Application no: **3/2021/0406**

Address: **Deli Solutions Ltd Lincoln Way Clitheroe BB7 1QD**

Proposal: **Discharge of Condition 5 (Construction Method Statement) of planning application 3/2018/0984.**

Site Sketch DJB/LW/03 - REV 'A'

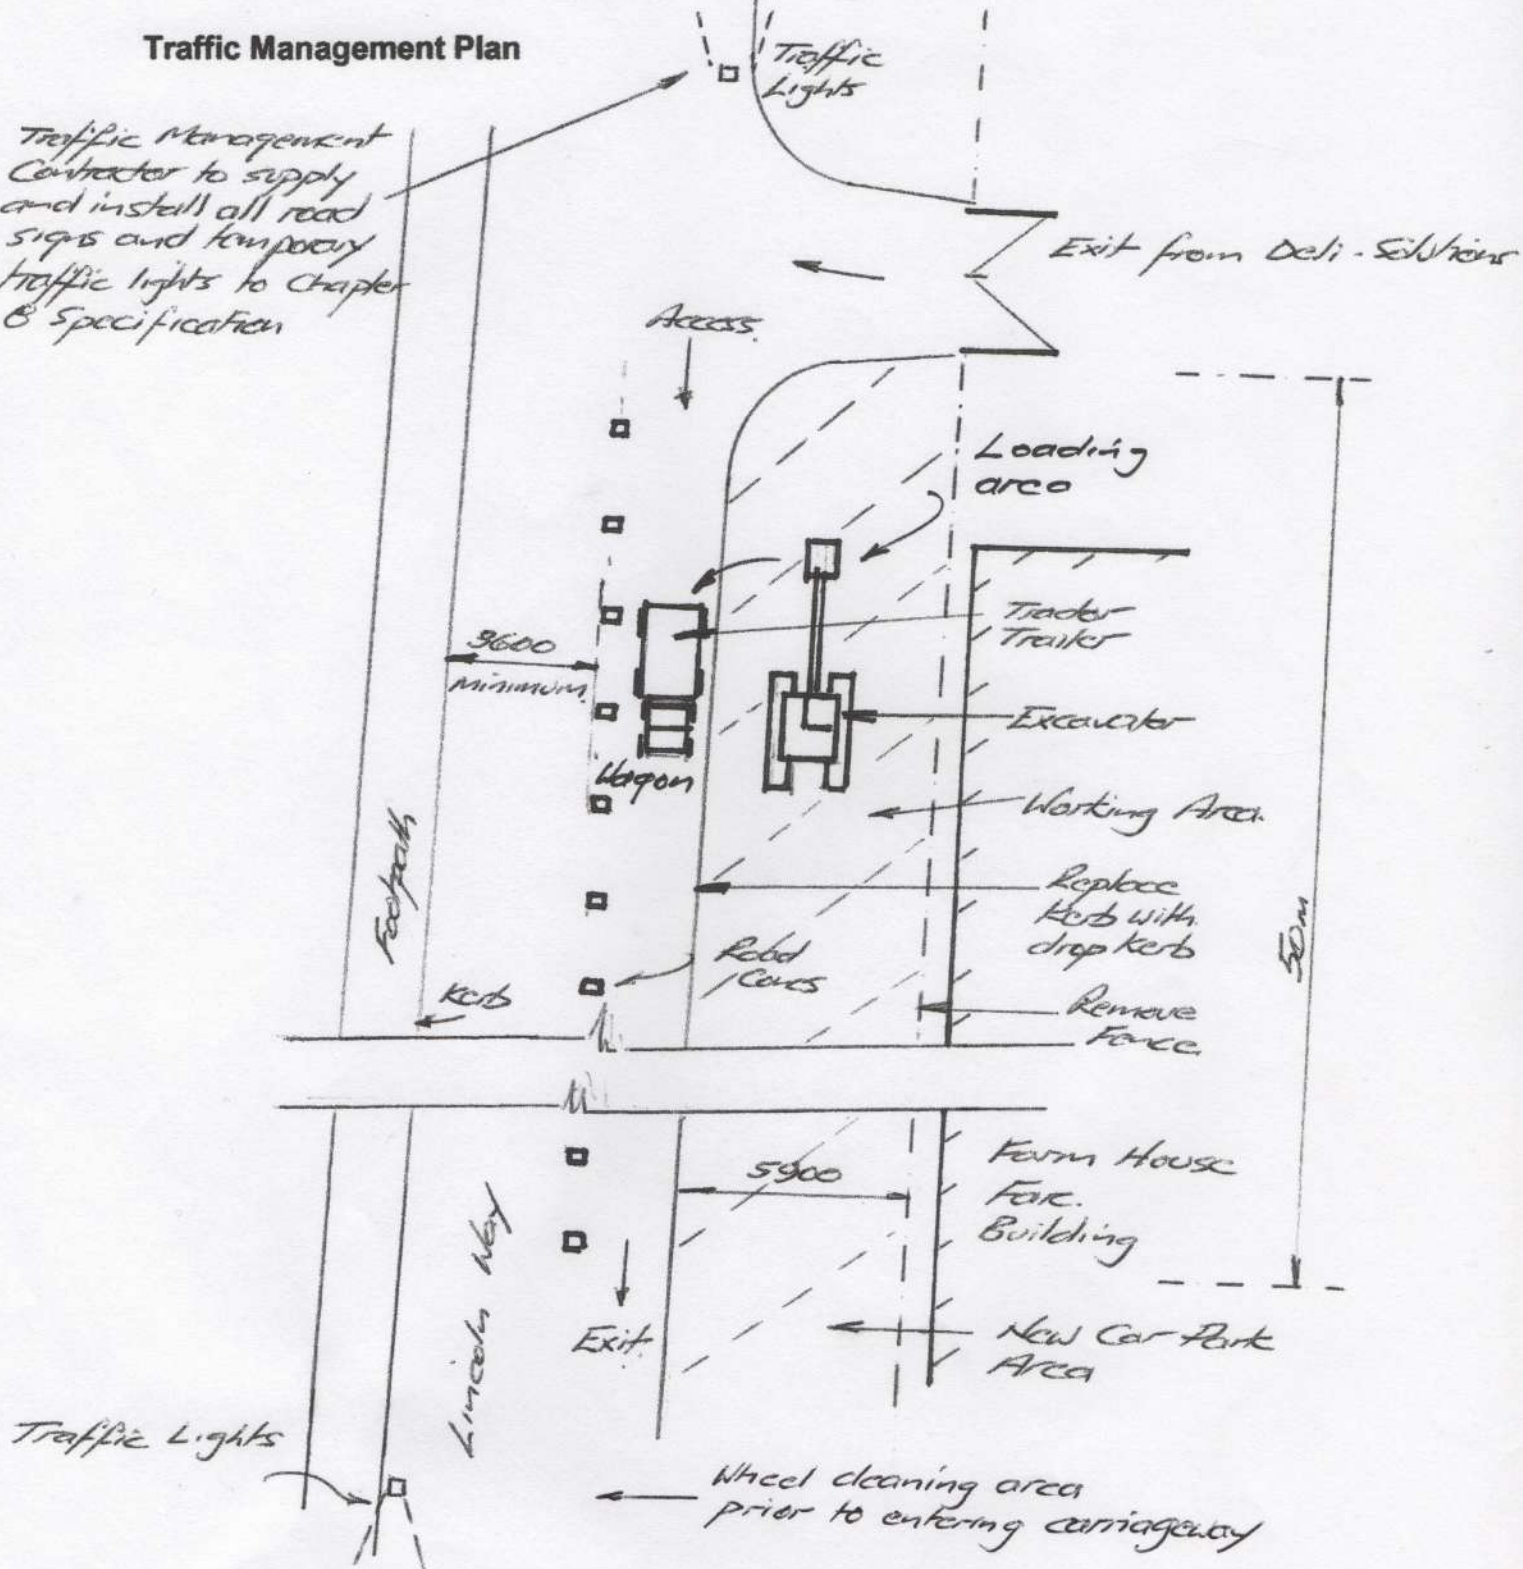
The LHA have reviewed David Johnston Builders drawing number DJB/LW/03 titled "Traffic Management Plan" and understands that during the construction of the site, one lane of Lincoln Way will be closed and replaced with two-way temporary traffic lights due to work being undertaken adjacent to the highway.

While the LHA have no objections against the use of the two- way traffic lights at the site should they be set out correctly, the drawing is contrary to Chapter 8 of the Traffic Signs Manual.

The LHA therefore require, a revised, detailed, scaled drawing detailing the location of the temporary traffic lights and the traffic signs located along Lincoln Way.
